MORGAN AND MORECAMBE OFFSHORE WIND FARMS: TRANSMISSION ASSETS

Annex 3.2.3 to Response to RR - Environment Agency (RR-677)

Document Reference: S_PD_3.2.3

11 April 2025
F01

Figure 1.8: Watercourse and waterbodies scoped in and survey numbers – Section 7A

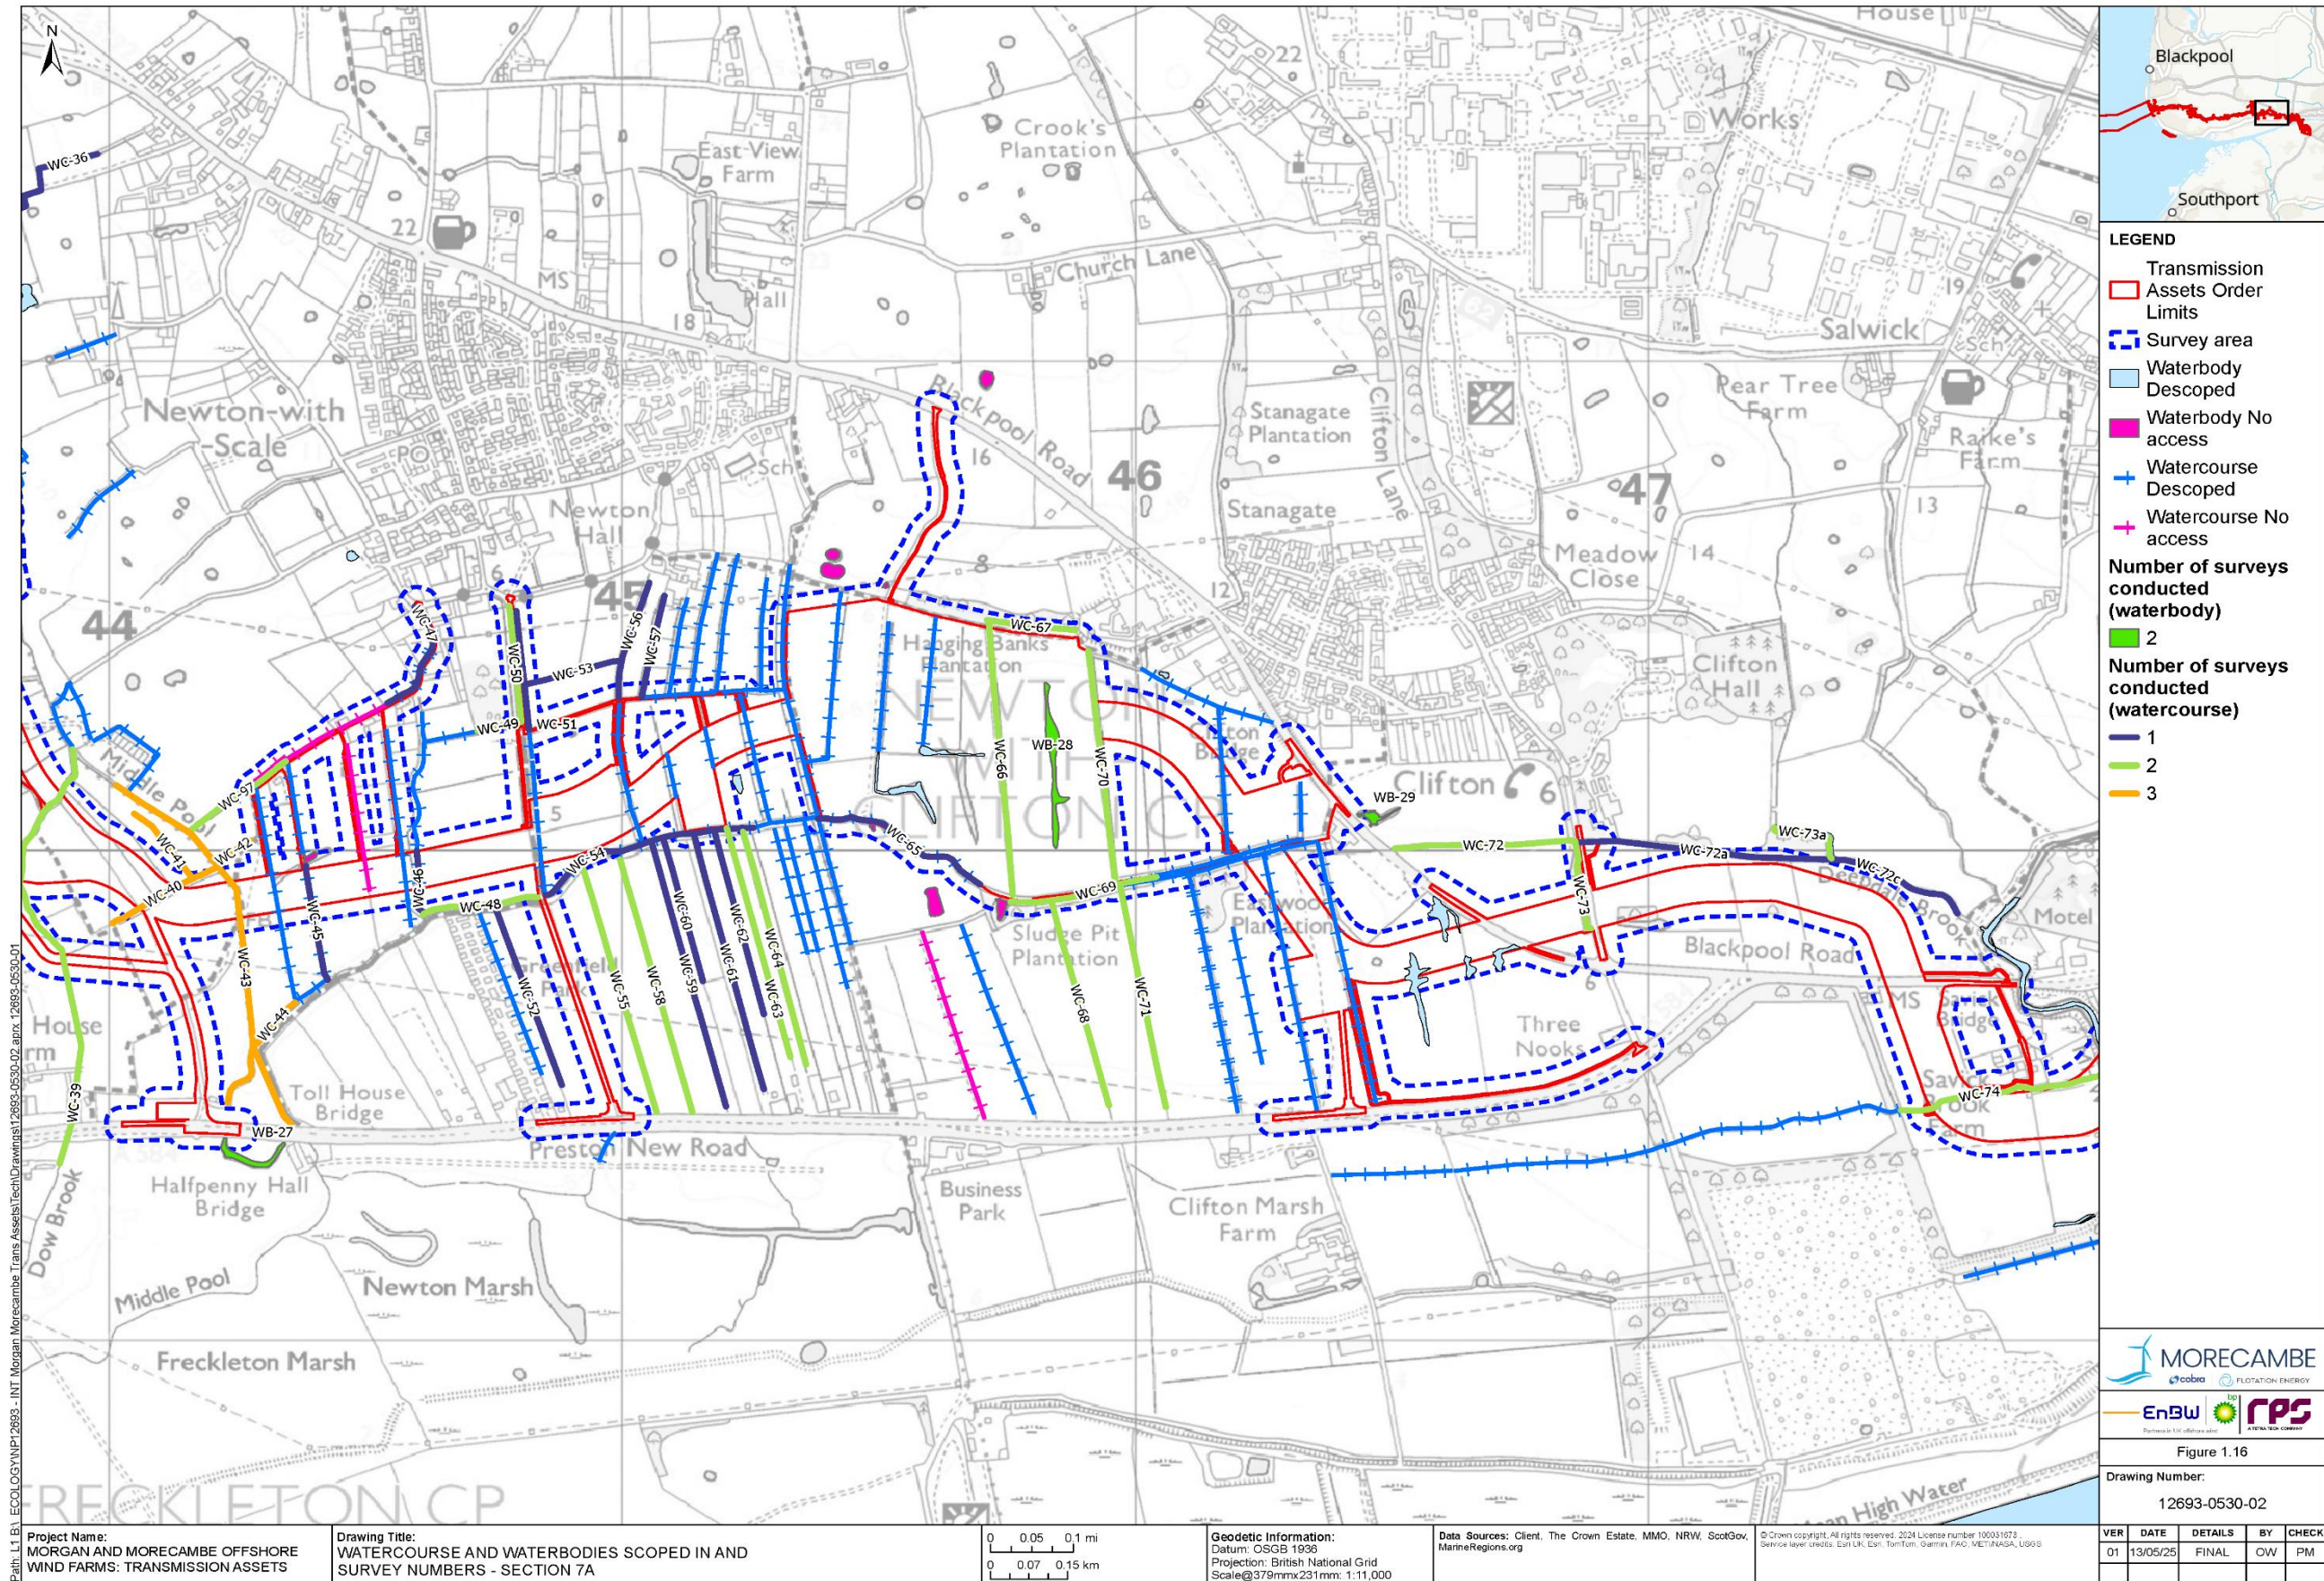
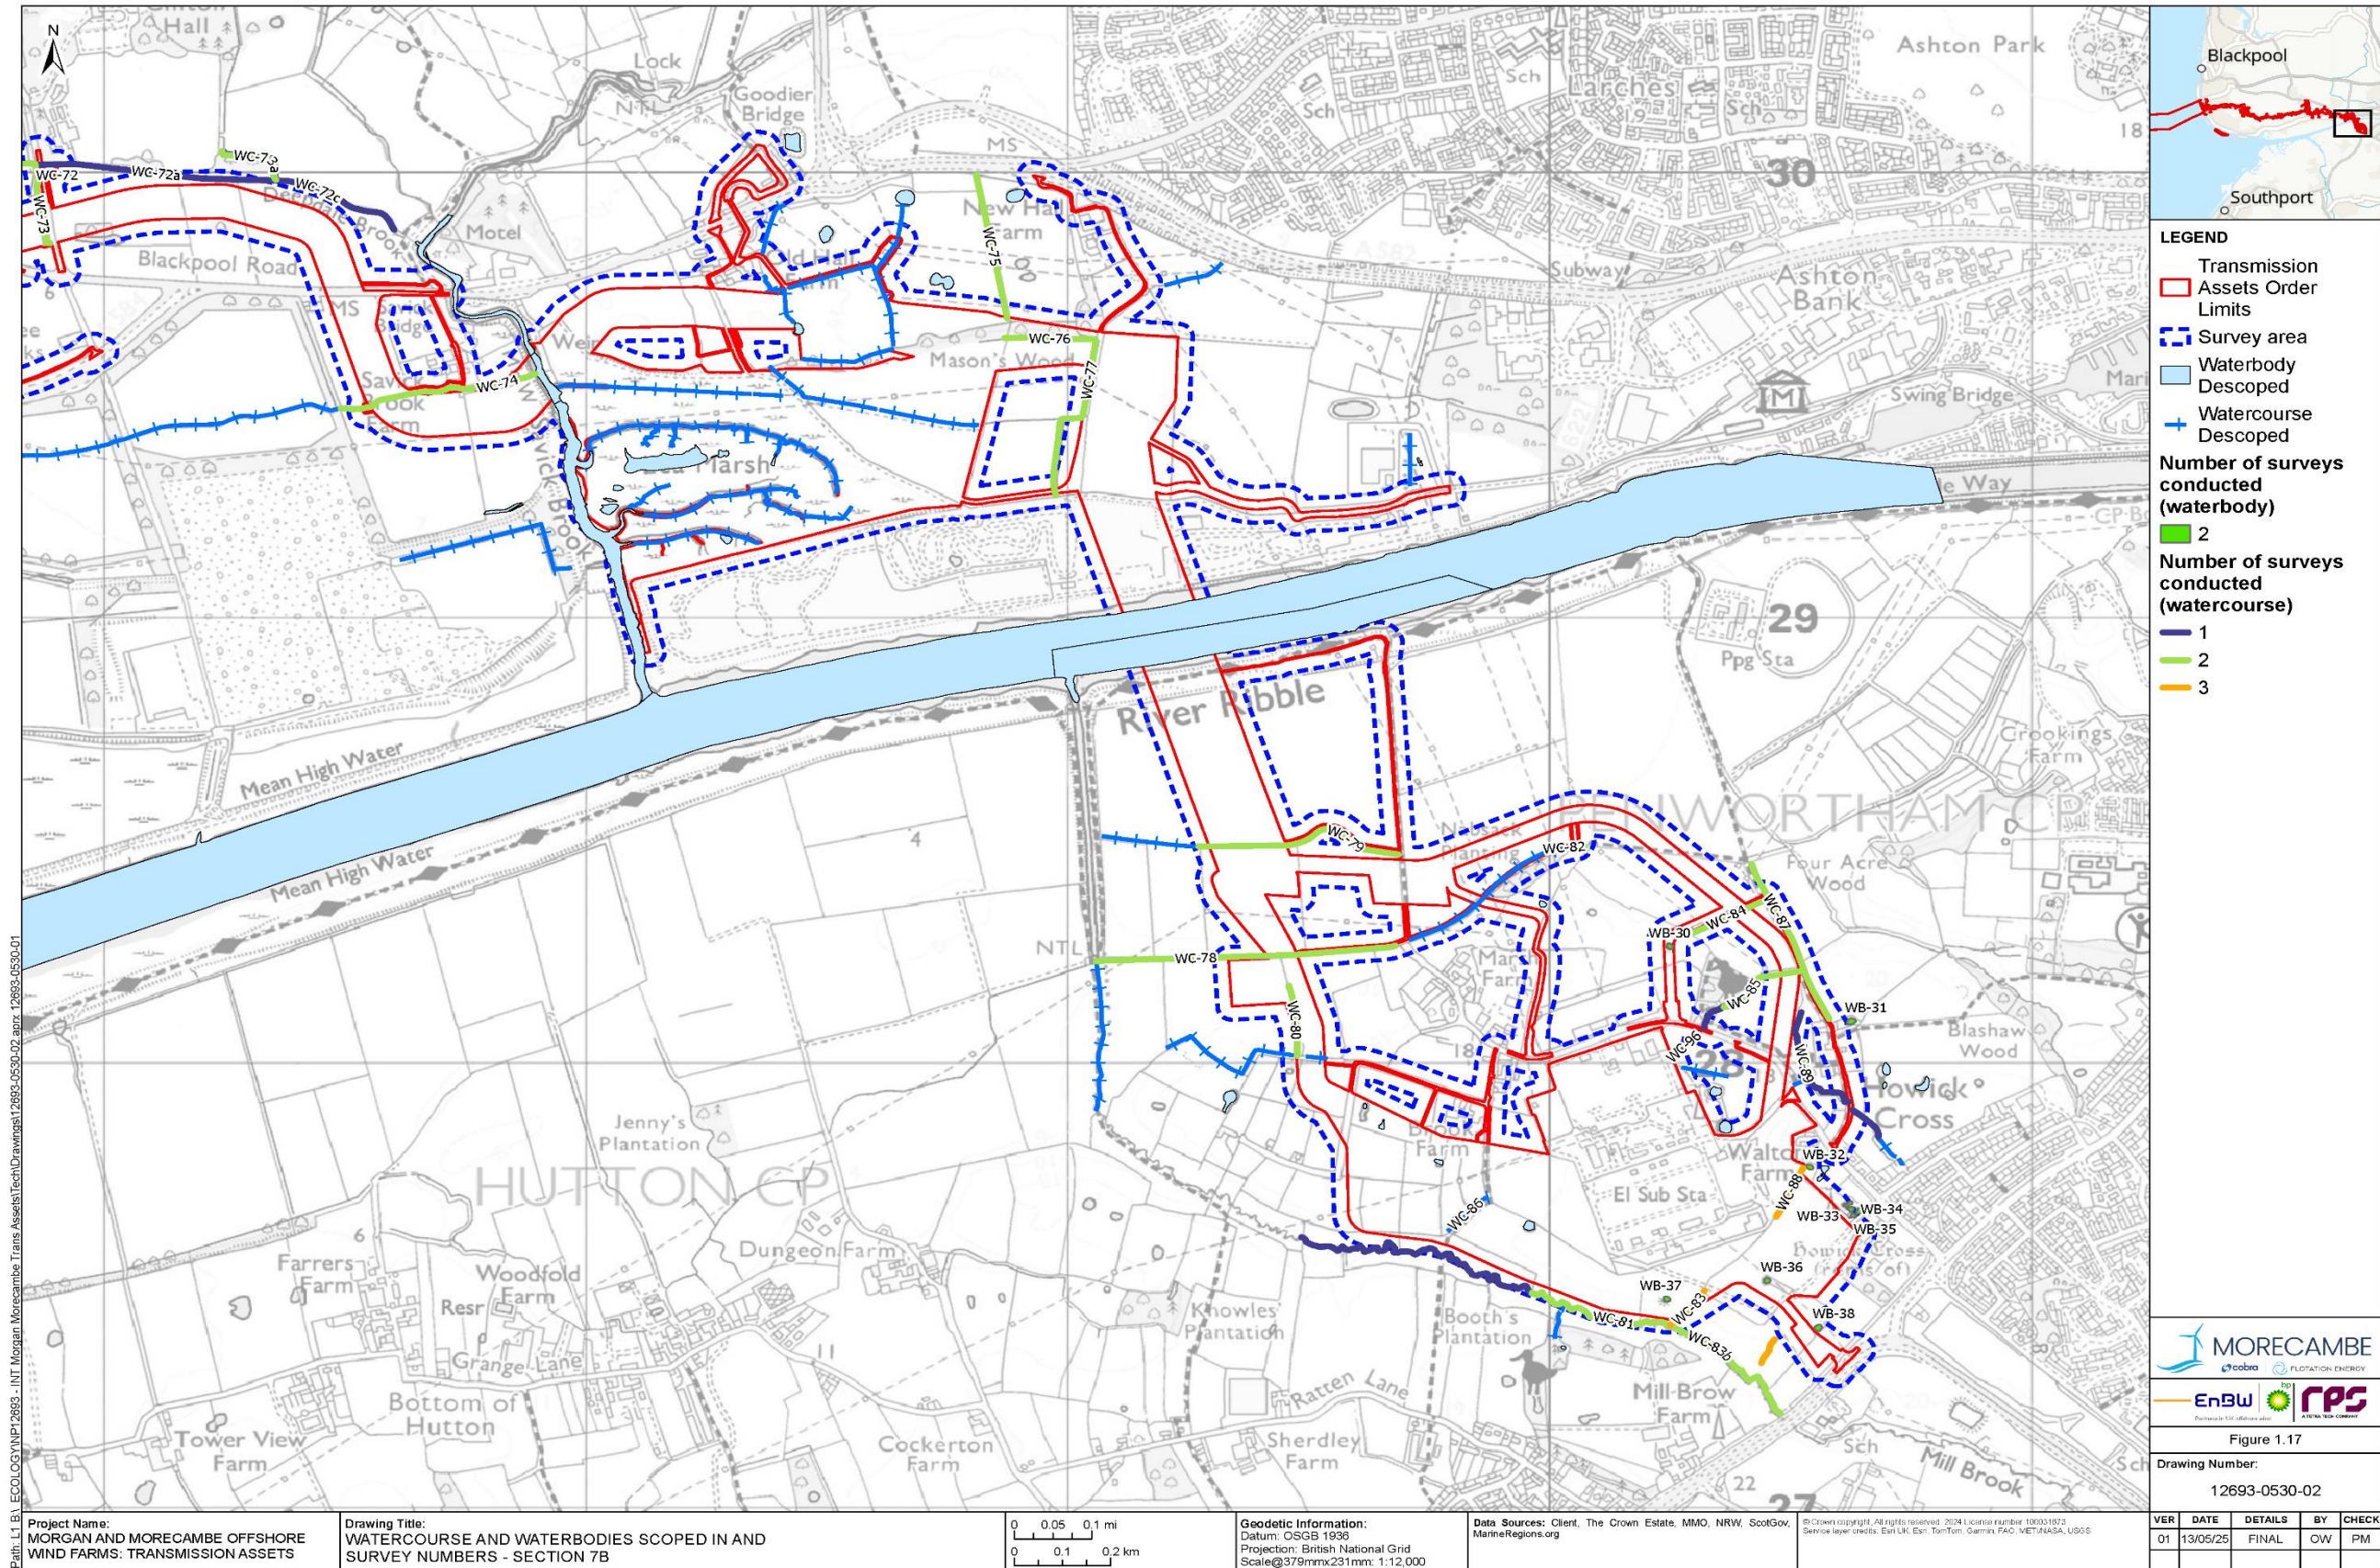
RR-0677 0677.12 (Appen. 1 APP-083)	<p>Water vole survey technical report</p> <p>Section 1.2.4.16 and 1.2.4.17: Water vole surveys have been undertaken following periods of weather extremes. The surveys in June 2023 were undertaken following an extended period of hot dry weather. The survey in April 2024 was undertaken following a period of heavy rainfall.</p> <p>Possible under-recording. Evidence of water vole are less likely to be recorded following dry weather, and evidence may be washed away during heavy rainfall.</p> <p>The report confirms that 'late season' water vole surveys were ongoing at the time of DCO submission. Once complete this report should be updated to reflect the results and submitted for review.</p>	<p>A campaign of water vole surveys was undertaken between April 2023 and July 2024 on land parcels with habitat that could potentially support water vole and where access was agreed. The surveys were undertaken in accordance with the methodology agreed with the Environment Agency (as part of the EWG) and the results were reported in Volume 3, Annex 3.9: Water Vole Survey Technical Report (APP-083). The water vole survey methodology requires two visits within the breeding season (i.e. early season (between mid-April to June) and late season (between July and September)).</p> <p>The Applicants responded to comments regarding the weather conditions during the June 2023 water vole surveys in Table 3.5 of Volume 3, Chapter 3: Onshore Ecology (APP-075) and subsequent surveys were undertaken in 2024 where access was permitted. A summary of the surveys (as set in Table 3.15 of APP-075) found there was little confirmed evidence of water vole and (together with the infrequent but widespread evidence of mink) considered water vole to be of local importance within the survey area. However, a precautionary approach was adopted for the assessment which assumed that water voles to be present where potentially suitable habitat had been recorded.</p> <p>The Applicants confirm that water vole surveys were undertaken in late August, September 2024 and the first week of October 2024 (as weather conditions allowed the</p>

Reference	Relevant Representation Comment	Applicants' response
		<p>surveys to be recorded as a 'late season' survey). These surveys formed part of the late season surveys that were being completed in accordance with the seasonal survey restrictions and the methodology of the previous water vole surveys. Given the timing of the surveys, the results were not included in the DCO application.</p> <p>The Applicants confirm that Volume 3, Annex 3.9: Water Vole Survey Technical Report (APP-083) will be updated to show the location of these surveys and will be submitted at Deadline 1 of the DCO Examination. The Applicants confirm that no new evidence of water voles was recorded during the late August to early October surveys and therefore, the characterisation of the baseline and the conclusion of the assessment as reported in Volume 3, Chapter 3: Onshore Ecology (APP-075) remain unchanged.</p> <p>Preconstruction surveys for European Protected Species (including water vole) will be undertaken (as secured in Requirement 13 of Schedules 2A & 2B the draft DCO (AS-004)). As set out in the Outline Ecological Management Plan (OEMP) (APP-212) the water vole surveys will be undertaken along all ditches of potential value to water voles that would be affected during construction.</p>
